September 30, 2013
File: 13105

RE: 133 YORK STREET
RESPONSE TO DAVID SENUS, P.E., MEMO DATED AUGUST 27, 2013

C1.1

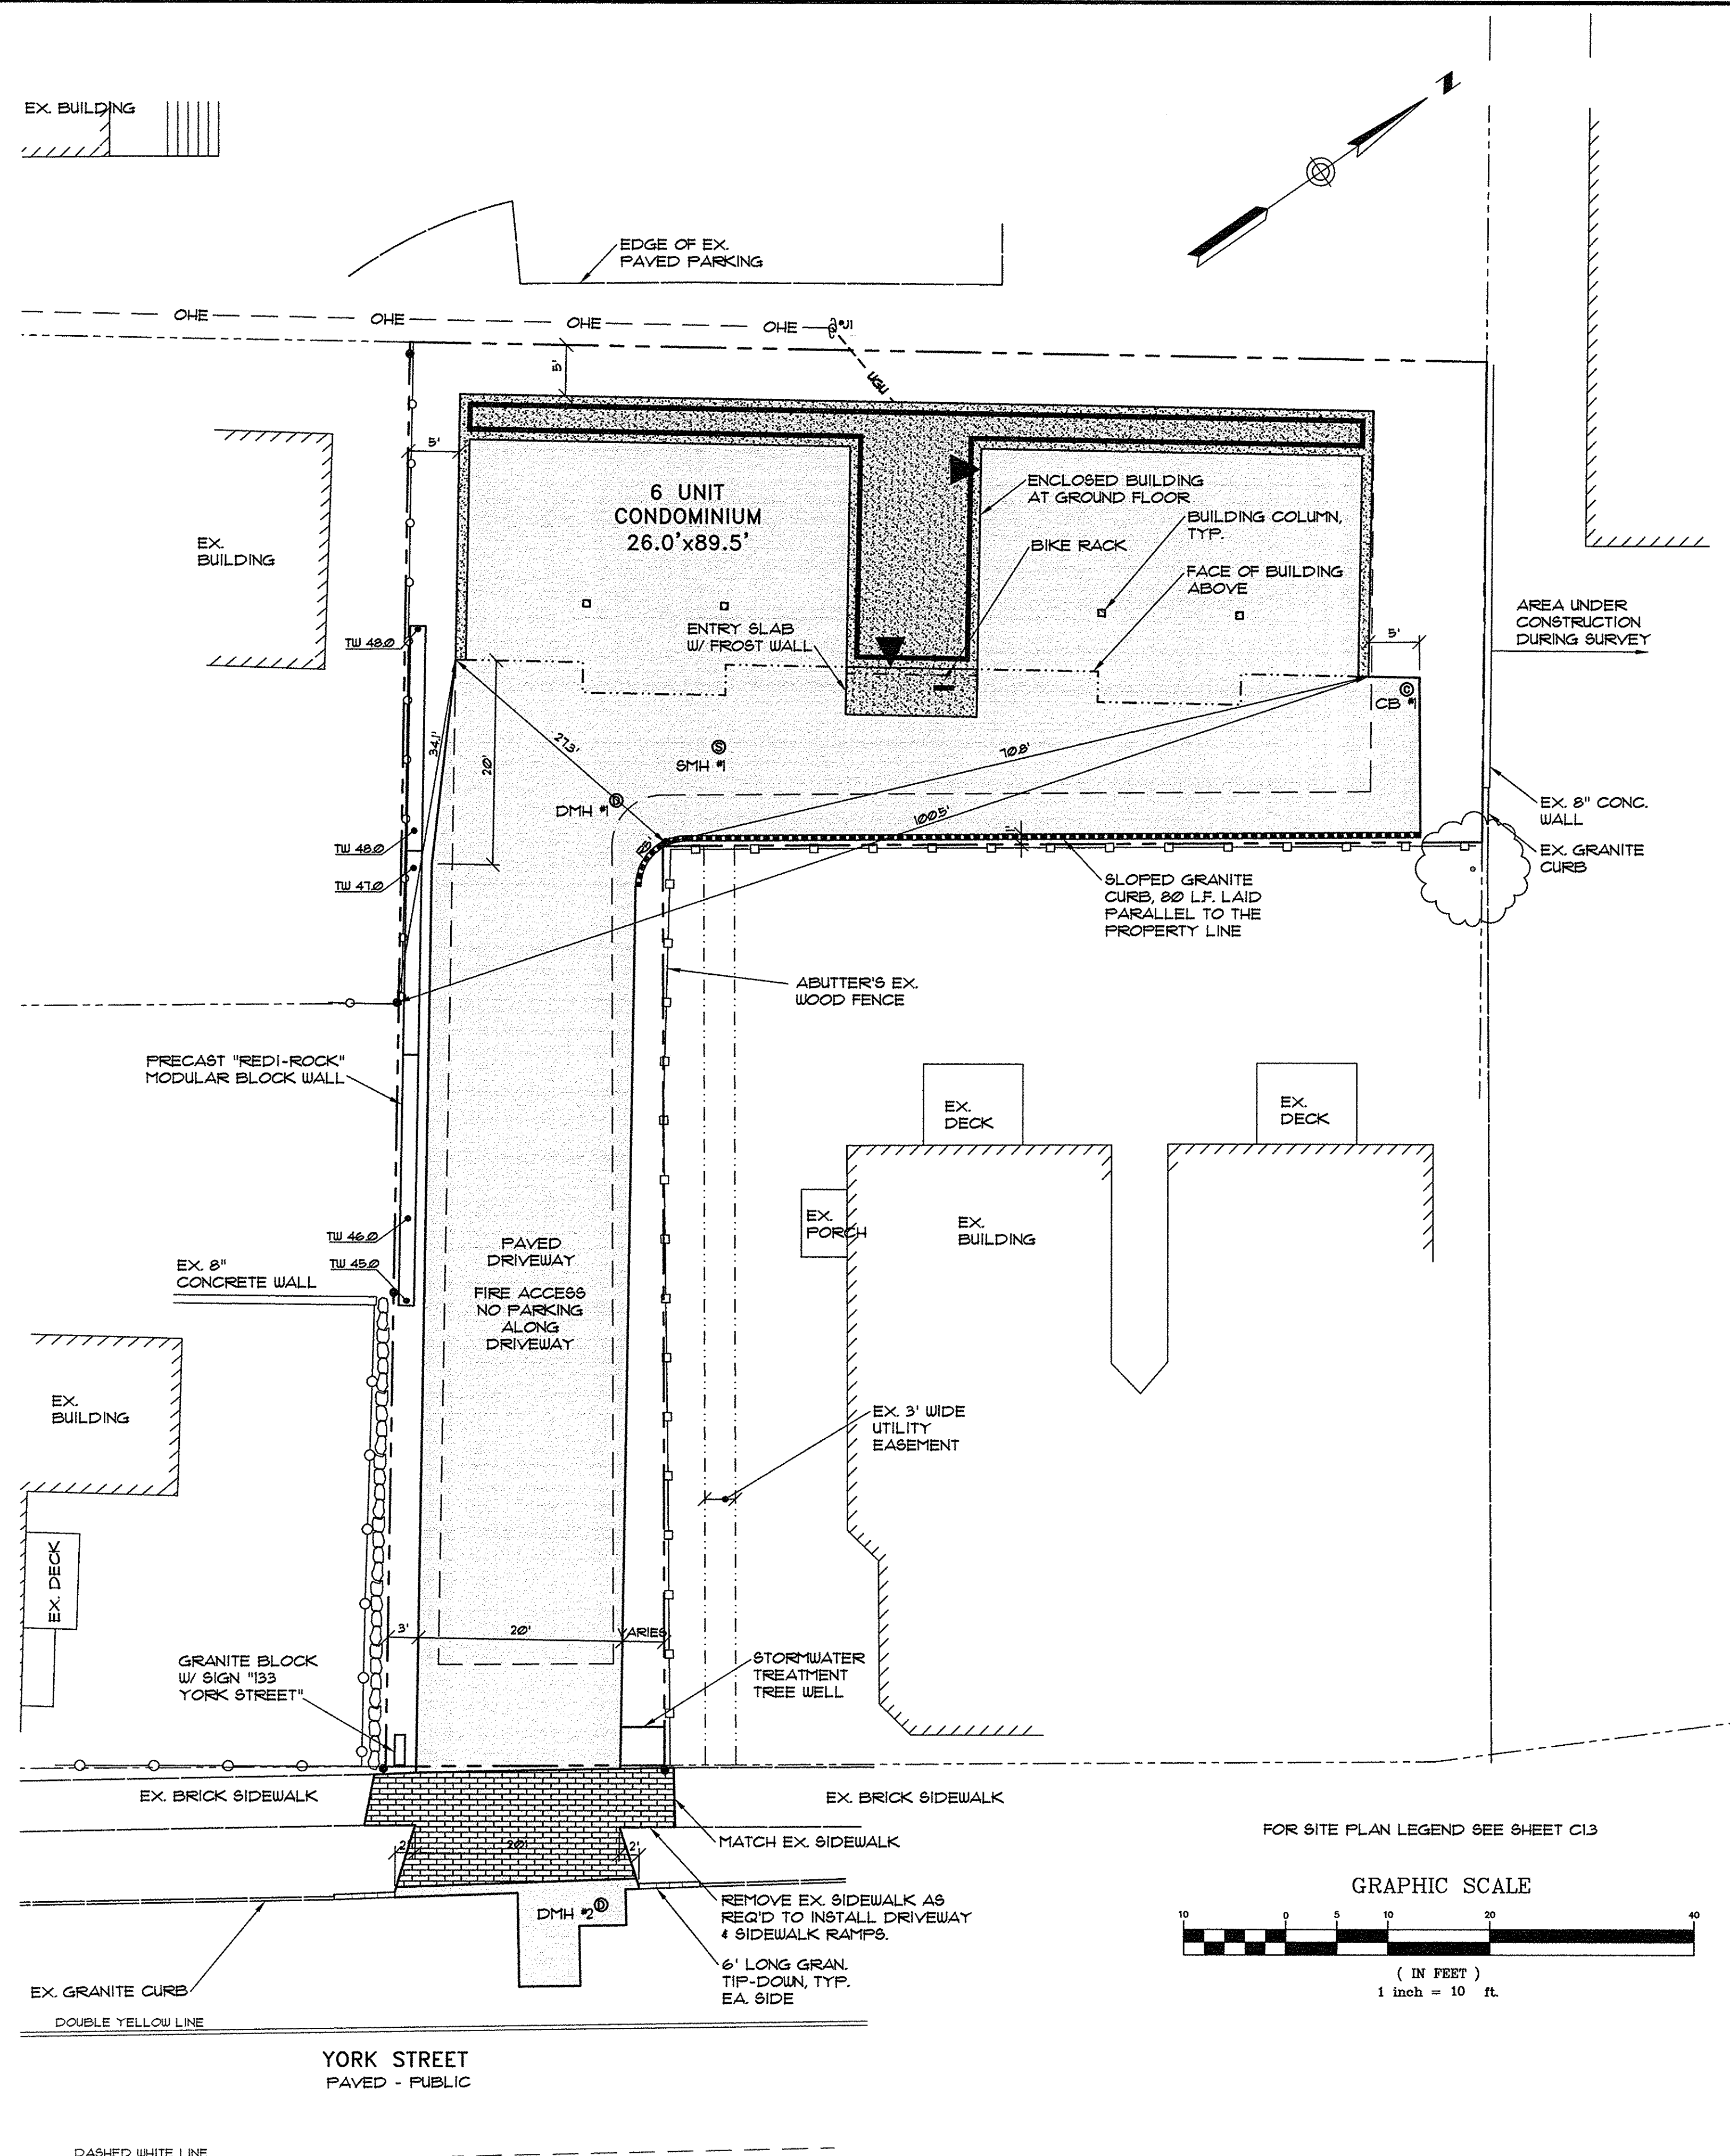
6. *Note 3 on C1.1 states that "All Powerline Utilities Shall Be Overhead"; however, a note on C1.3 indicates an underground connection from the utility pole at the rear of the building; please clarify. In addition, it appears that an easement will be required from McCormick Place Condominium for this underground utility connection.*

The existing utilities access the site in that location.

C1.4

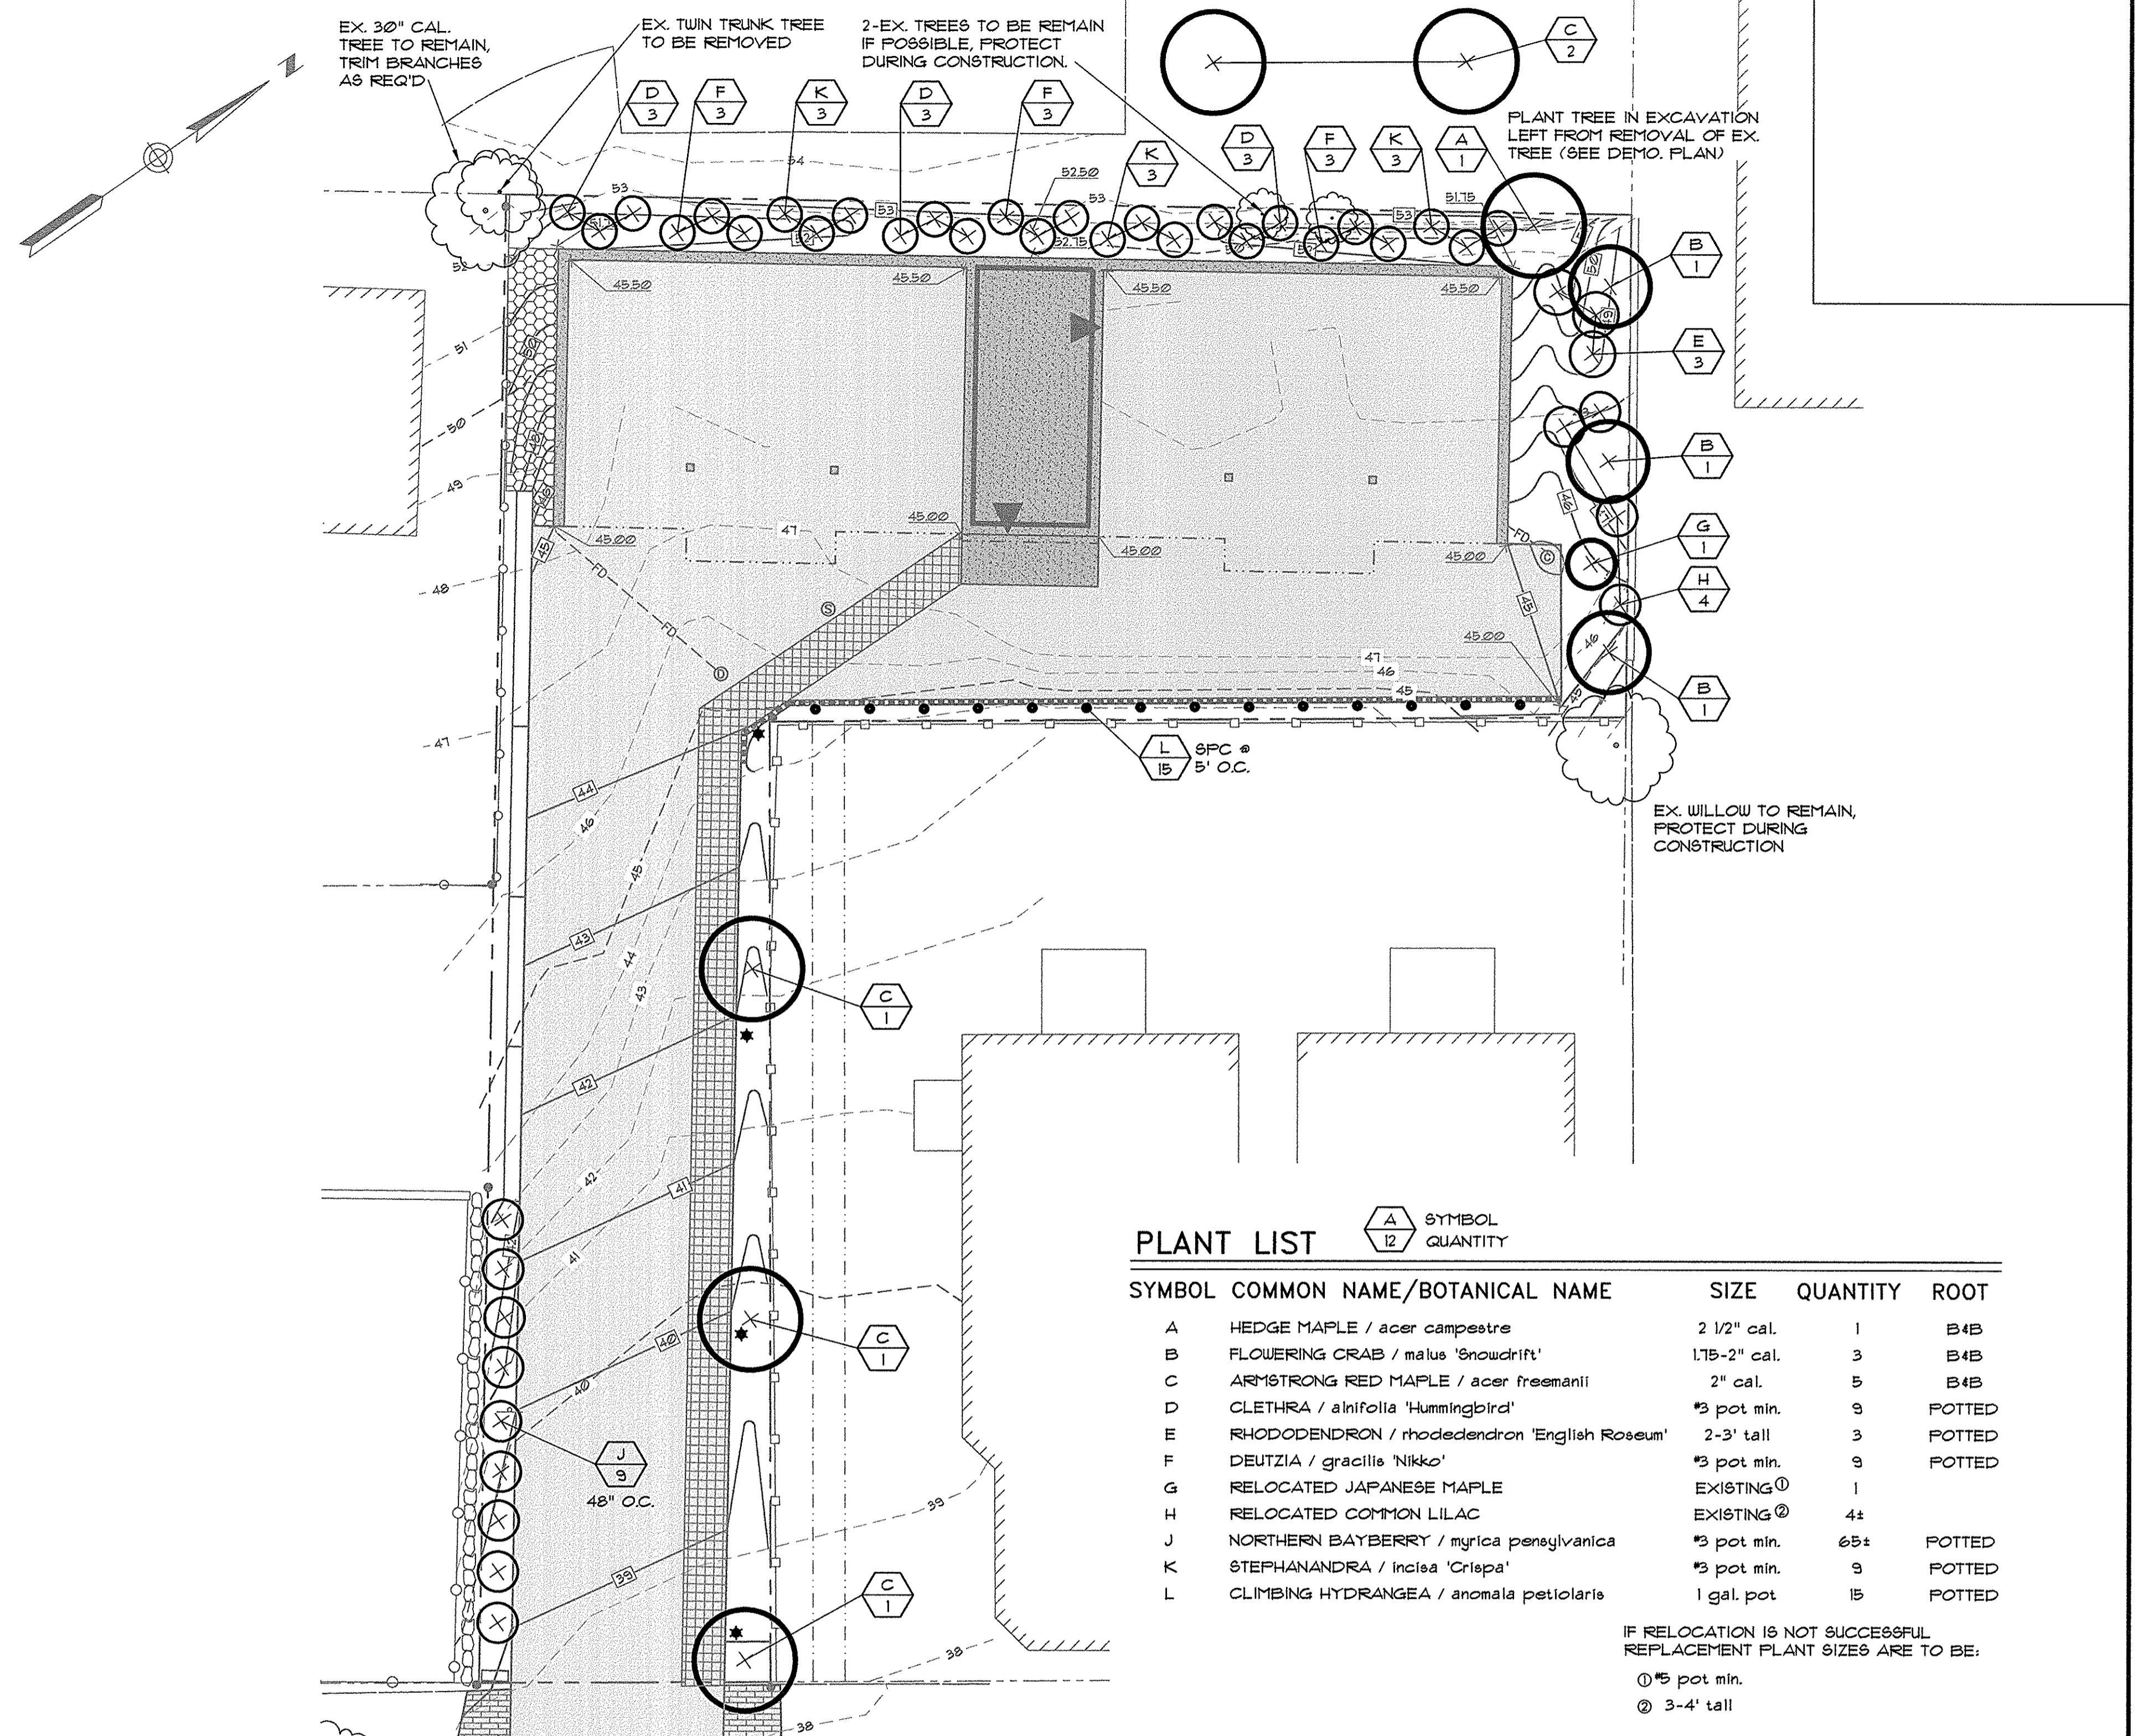
a) *Basic Standard: Plans, notes, and details have been provided to address erosion and sediment control requirements, inspection and maintenance requirements, and good housekeeping practices in general accordance with Appendix A, B, & C of Maine DEP Chapter 500. In addition to the notes and details contained on the plans, consider adding a temporary stabilization measure within the shallow swale on the east edge of the driveway.*

We have added mesh to the swale above the tree filter.
